11/08/2020

**St Francis College Stage 1 - Landscaping (SSD-10365)  
Response to Submissions**

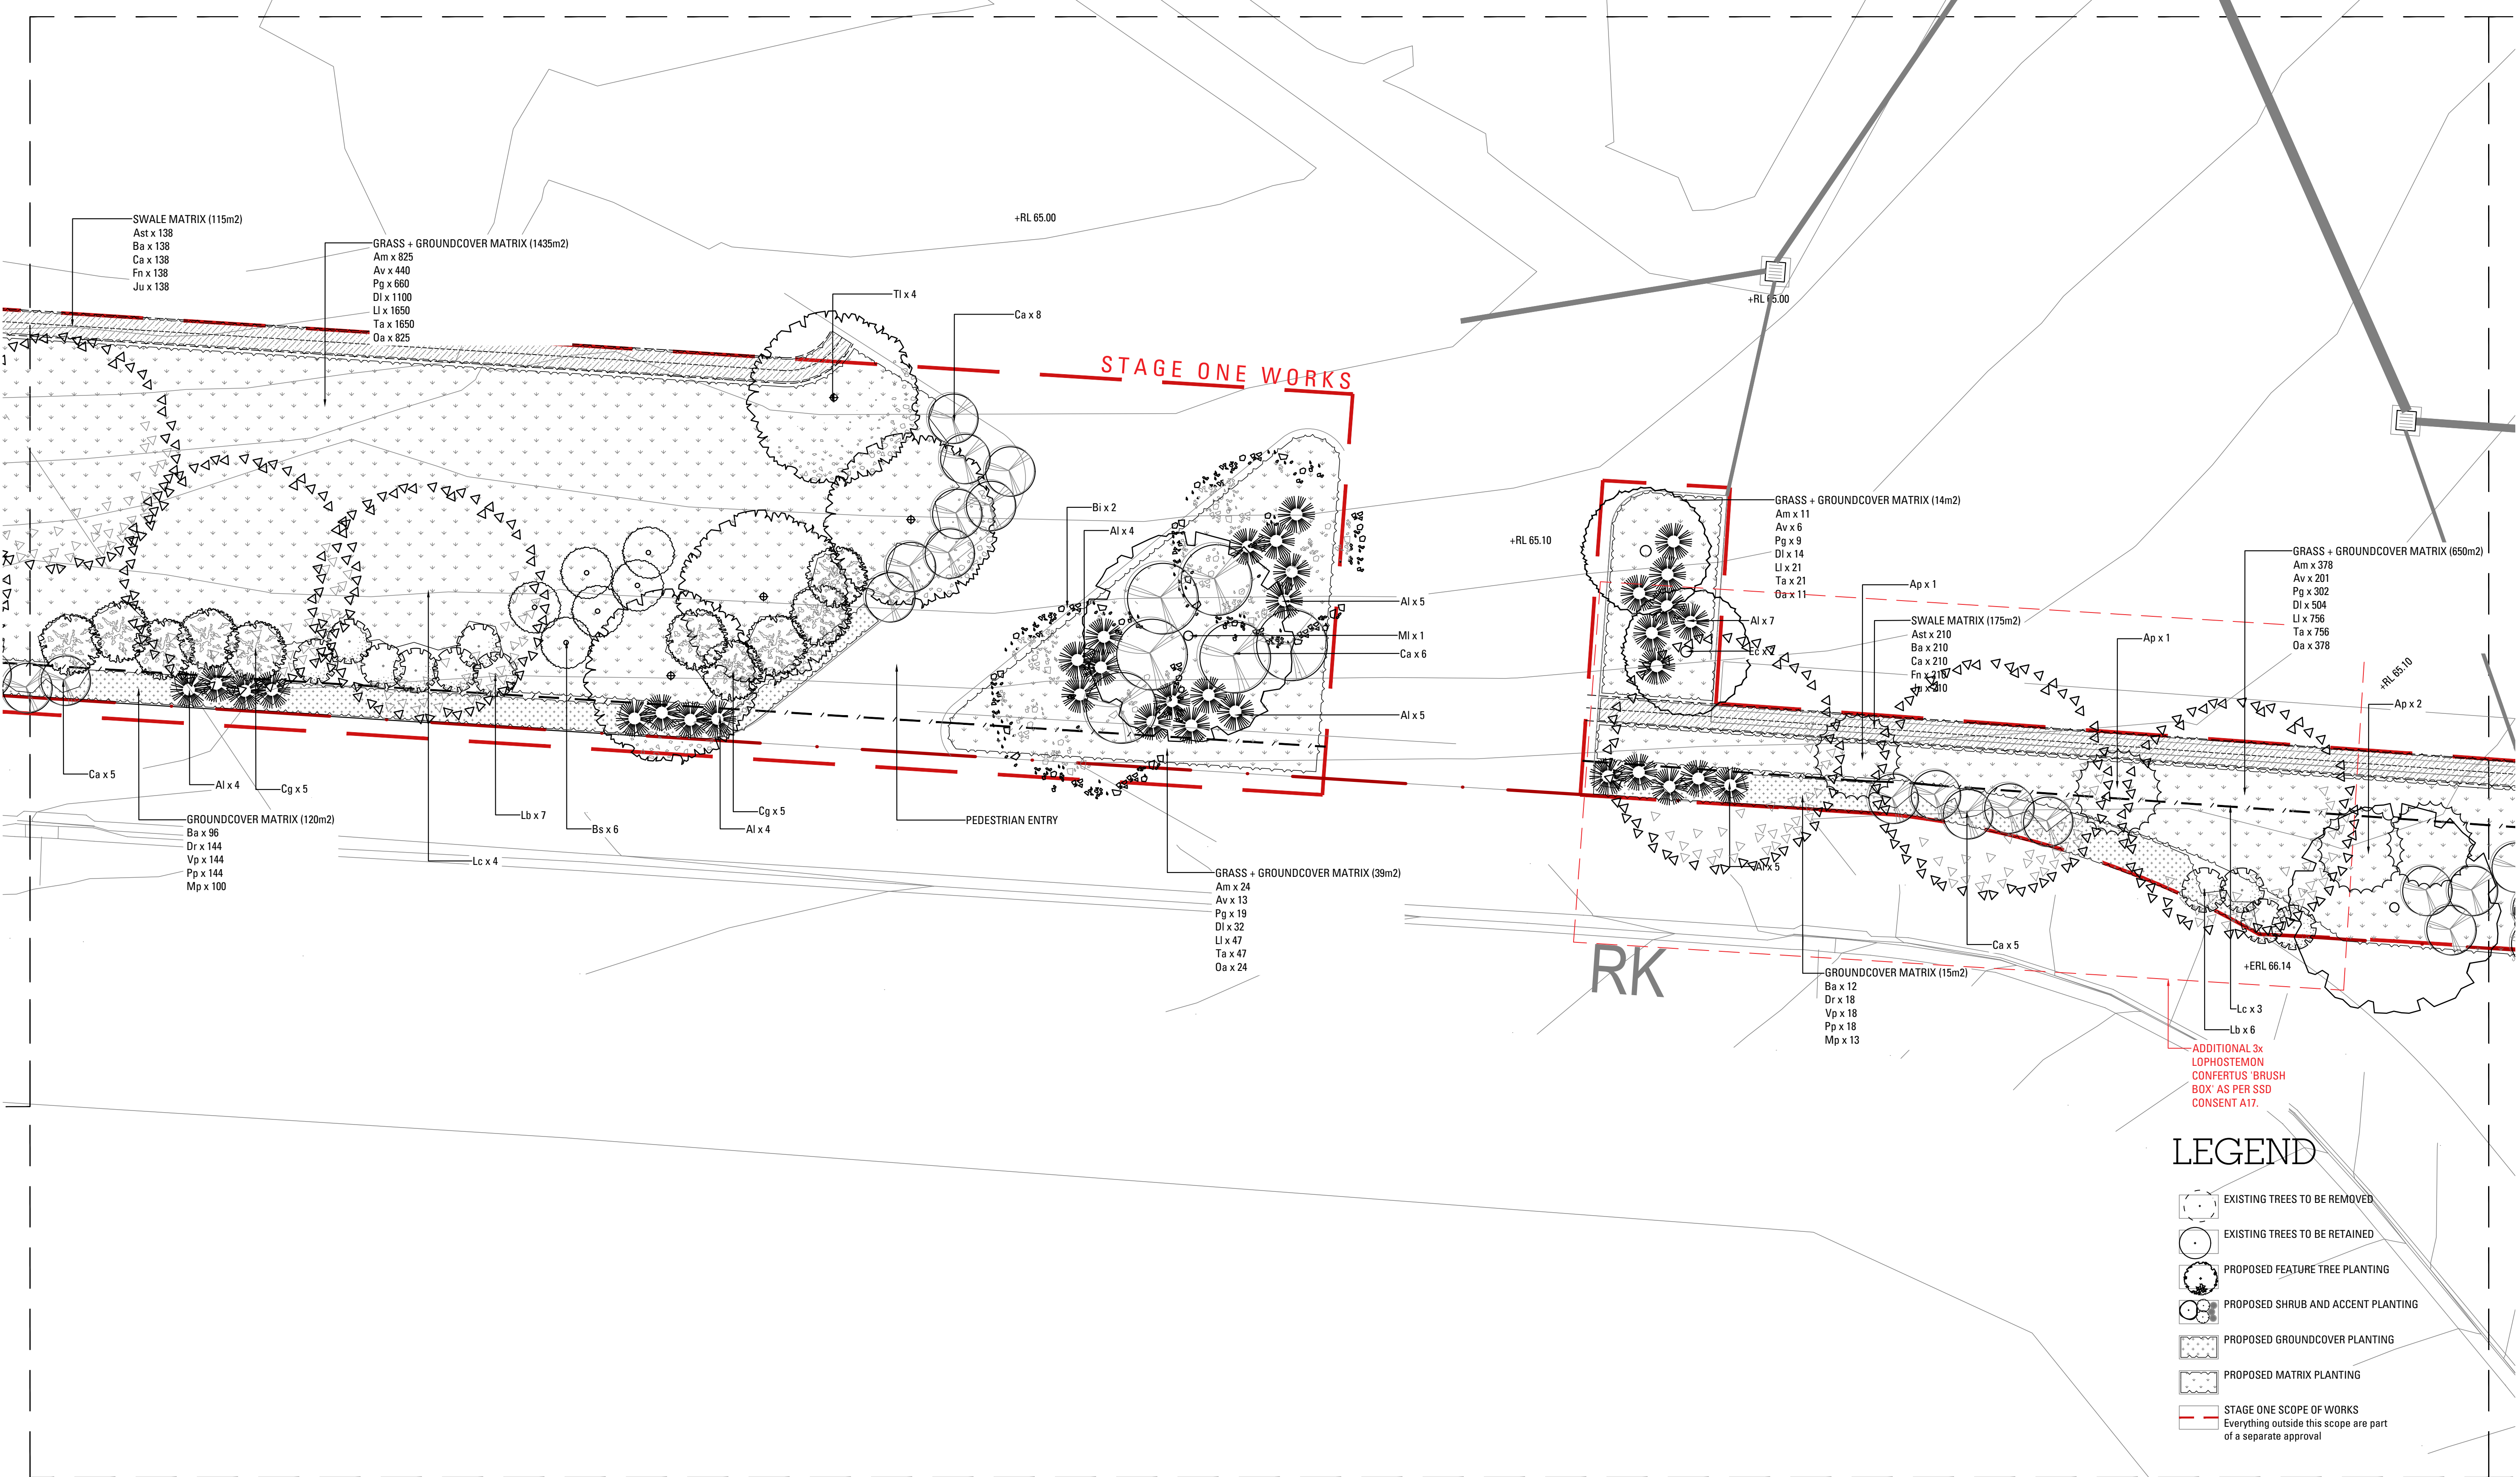
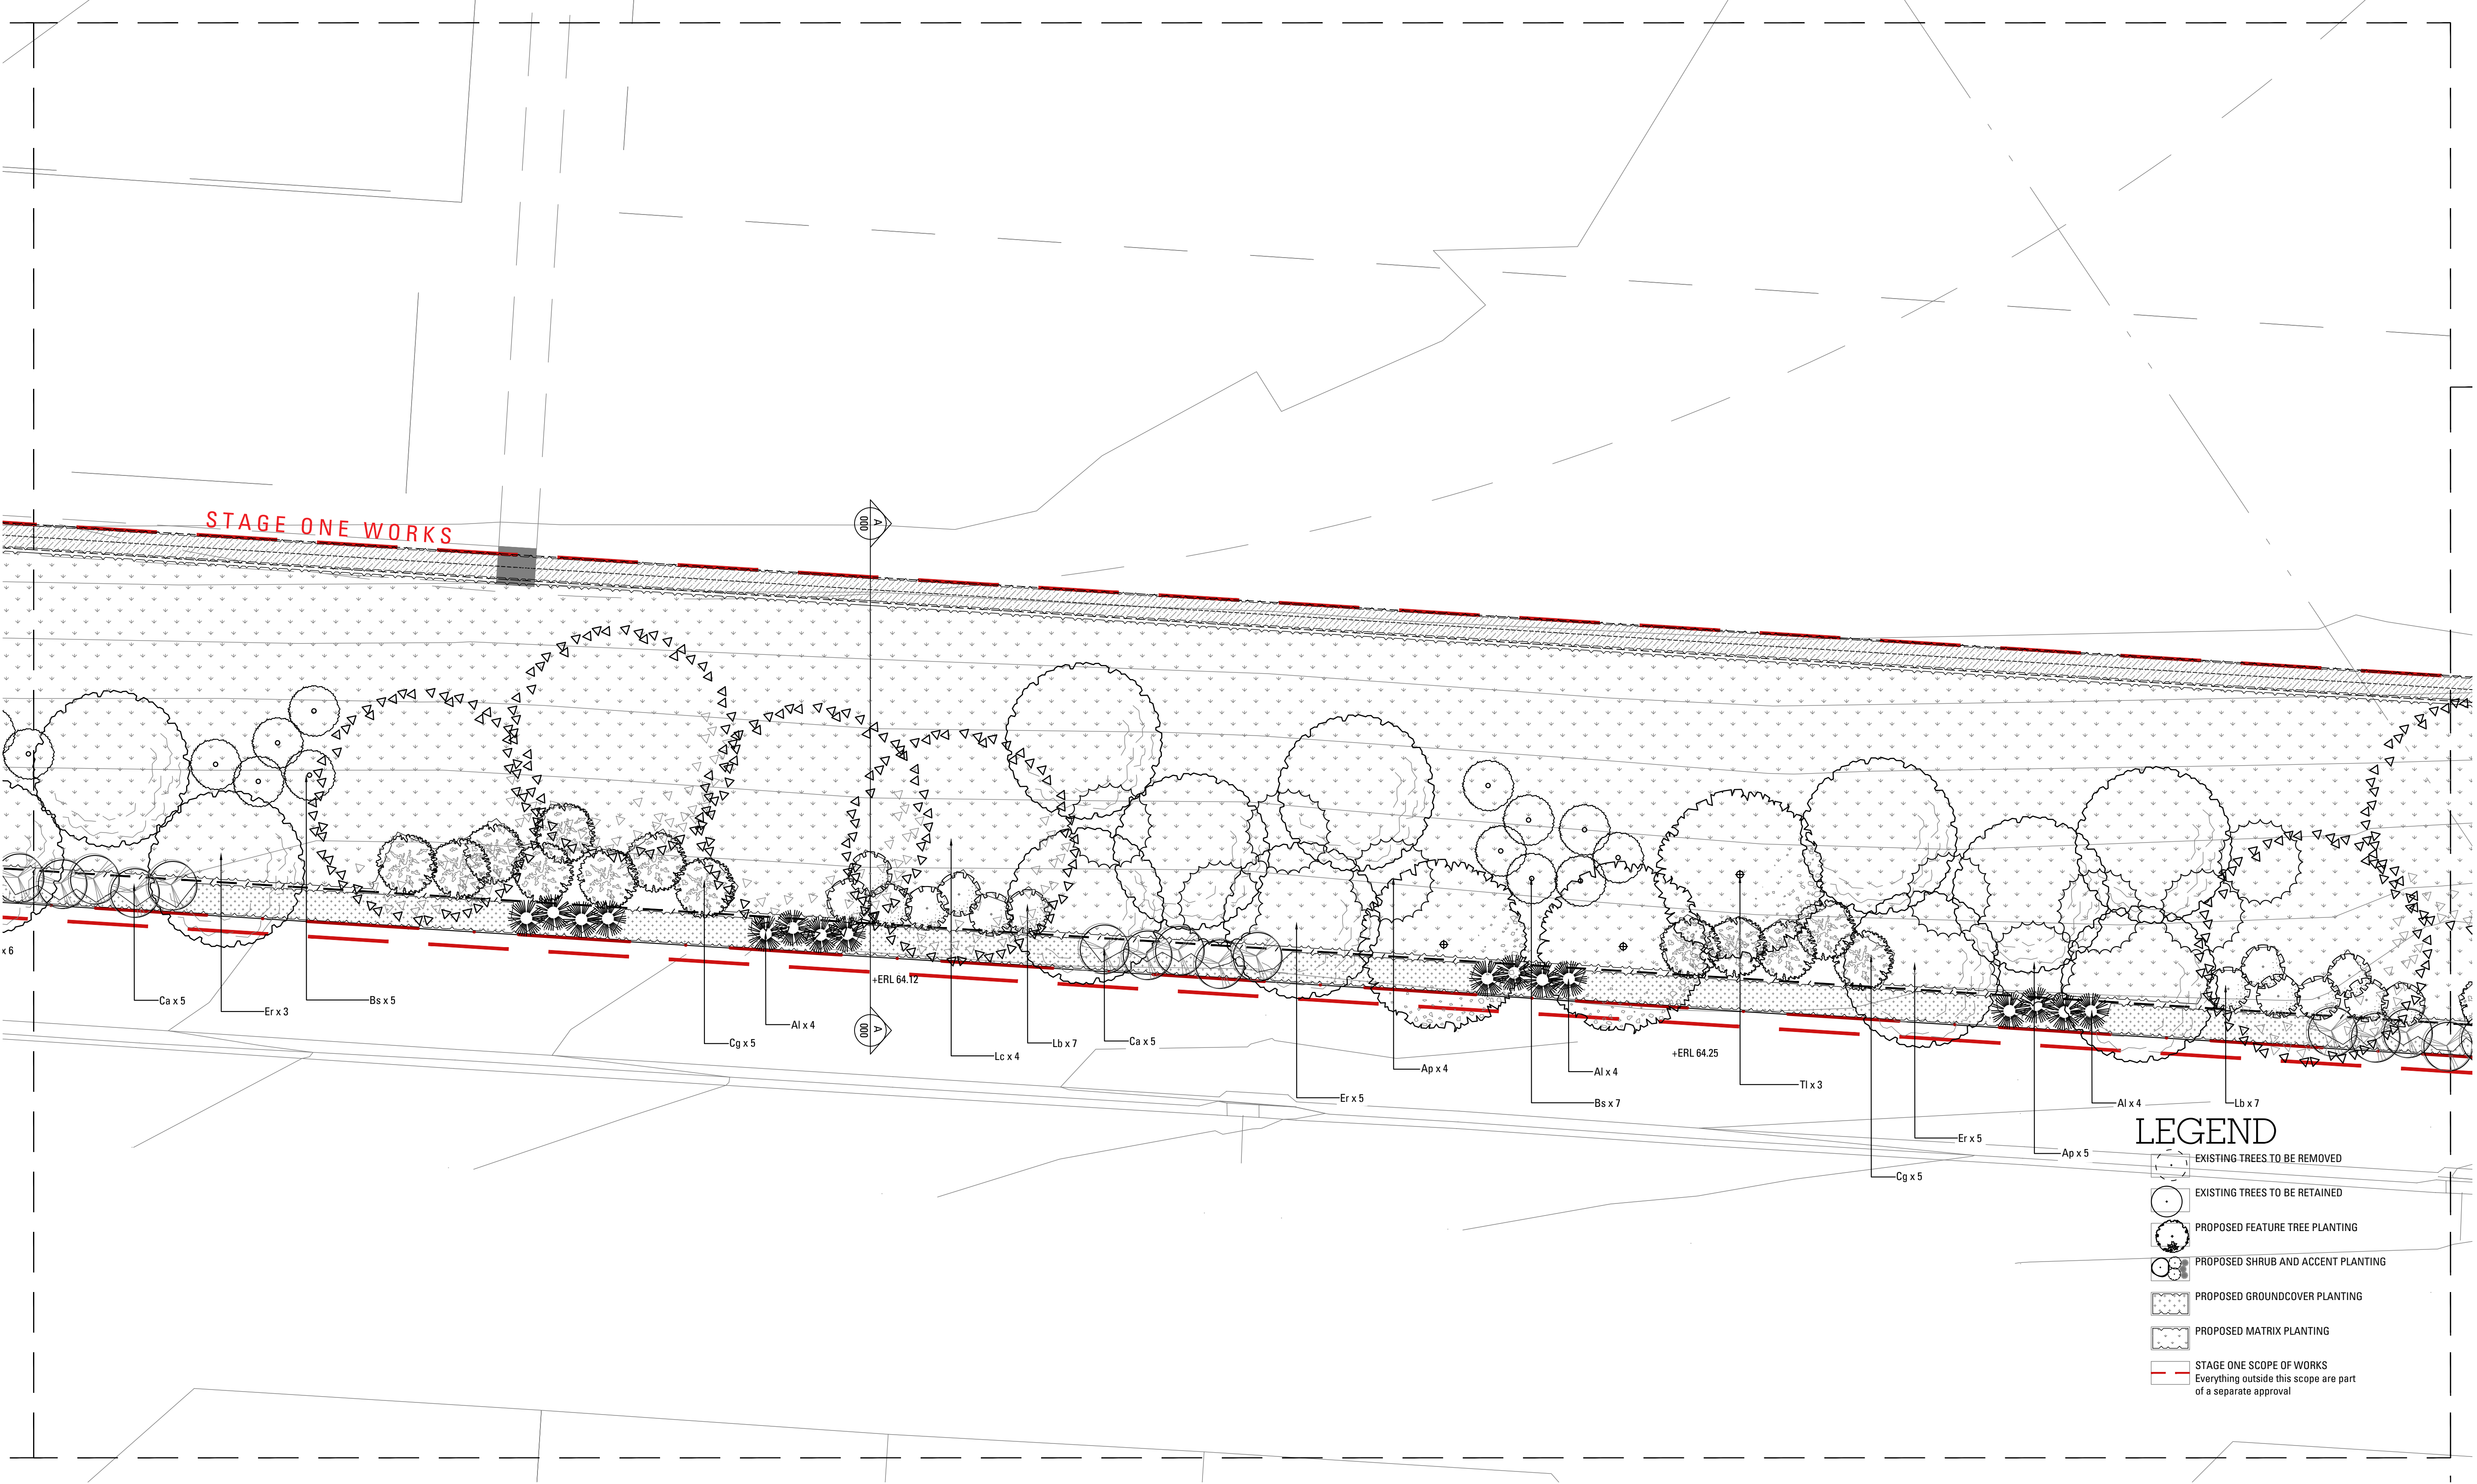
- The submitted Proposed Site Plan (reference: 1130 SSD11 Rev 01; dated: 11/02/2020) does not clearly identify the development footprint for which approval is sought under this development application. Plans intended for approval need to clearly identify the proposed development footprint for Stage 1. Any works falling outside of the development footprint would require a separate consent and would be treated as indicative only. It is suggested that an appropriate key be used to distinguish and identify Stage 1 works from other works shown on the plan for context
